**Re: Planning Application 21/0205**

**Address: Land at Neddy Lane Billington BB7 9LL**

**Description: Proposed erection of 36 residential dwellings, along with landscaping and associated site infrastructure.**

Simon Hardie  
Highways Development Control  
Lancashire County Council

Extents of Adoption Plan

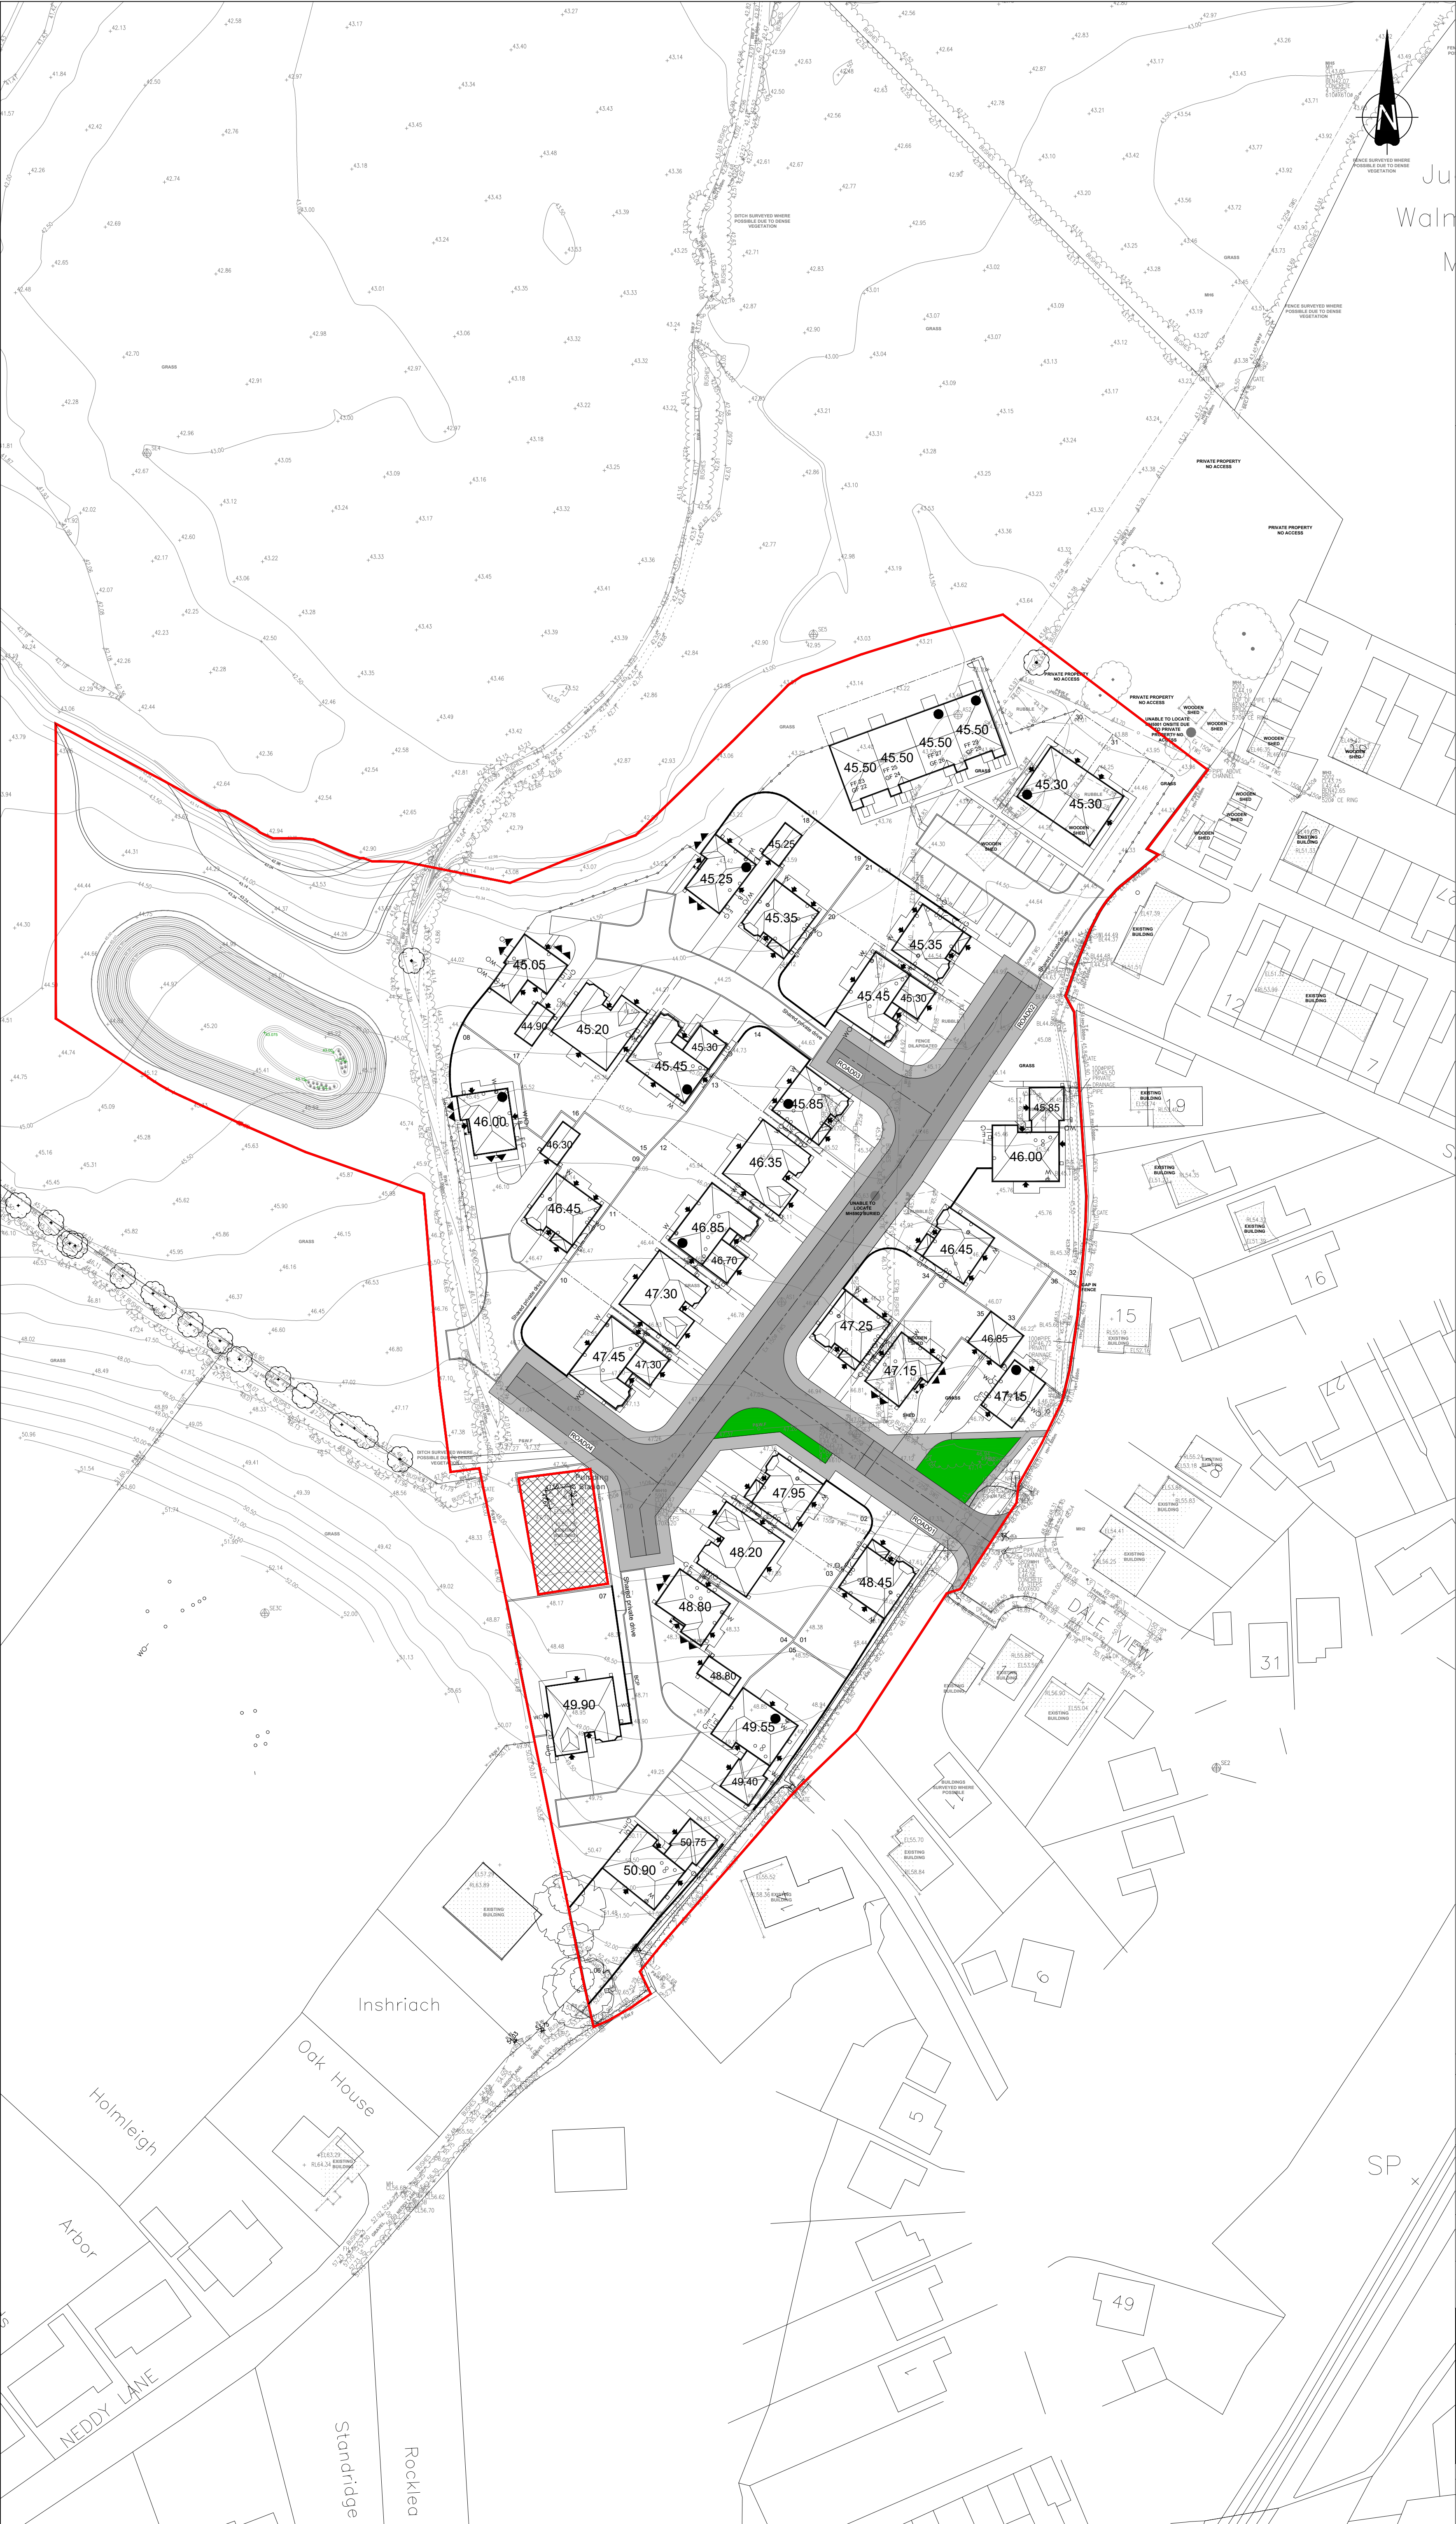
There will need to be some additional traffic calming measures built into the junction with Dale View these are expected to be along the lines of a junction table and other similar measures on the approaches to the junction.

- All the footways within the site will need to be adjacent to the carriageway

- The Public Rights of Way across the site may need to be altered
- United Utilities will need to be consulted to ensure that all vehicles that are like to require access to the pumping station can be accommodated, this may require the provision of some off-street parking.
